9 November 2017

610.14692-L01-v0.1 RTS Water Quality 20171109.docx

Mortdale Resource Recovery Facility Response to DPE Comments Regarding Water Quality

ROCLA FIRST
DEFENCE DETAIL
NOT TO SCALE

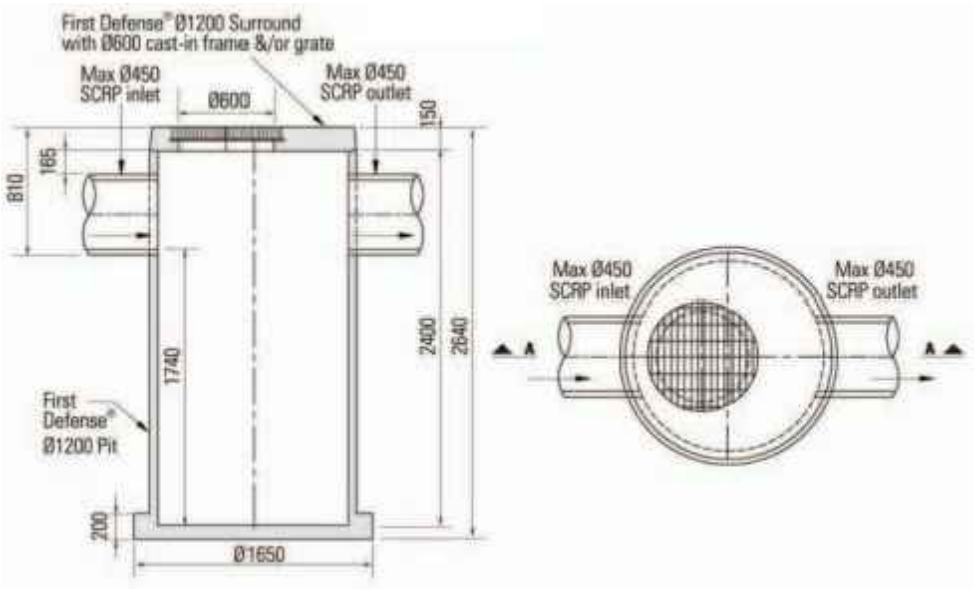
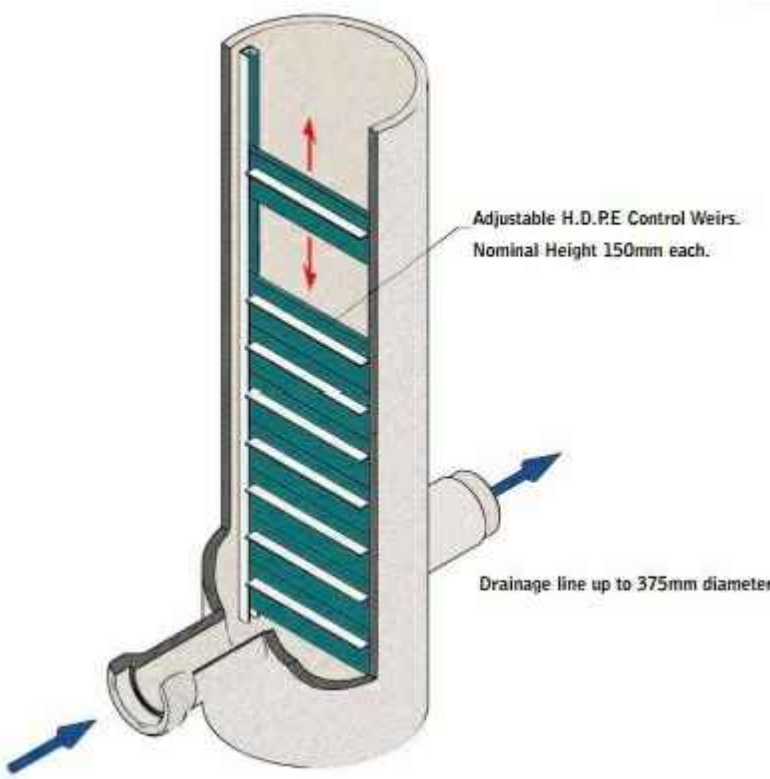
The previous stormwater strategy proposed the use of a Rocla First Defence GPT. The *First Defence* treatment device would improve water quality from the existing situation. The *First Defence* provides treatment in terms of sediment, suspended solids, free oil and sediment bound heavy metal removal, but is not effective in removal of nutrients (Phosphorous and Nitrogen).

To achieve the pollutant reduction targets, particularly nutrients, the proposed GPT has been changed to a Humes Jellyfish Gross GPT.

- Use of a Humes Jellyfish GPT (Not Rocla’s First Defence unit as originally proposed);
- 45kL rainwater tank and associated drainage to collect runoff from approximately half of the roofed area;

The MUSIC modelling carried out with this study includes a Humes Jellyfish GPT with membrane cartridges that provide improved fine particle and nutrient removal rates. The pollutant removal rates published by Humes and achieved from independent testing are as follows: TSS 85%, TP 59%, TN 51%, Cu 90%, and Zn 70%. Other types or arrangements of GPT with similar pollutant removal rates should also be satisfactory.
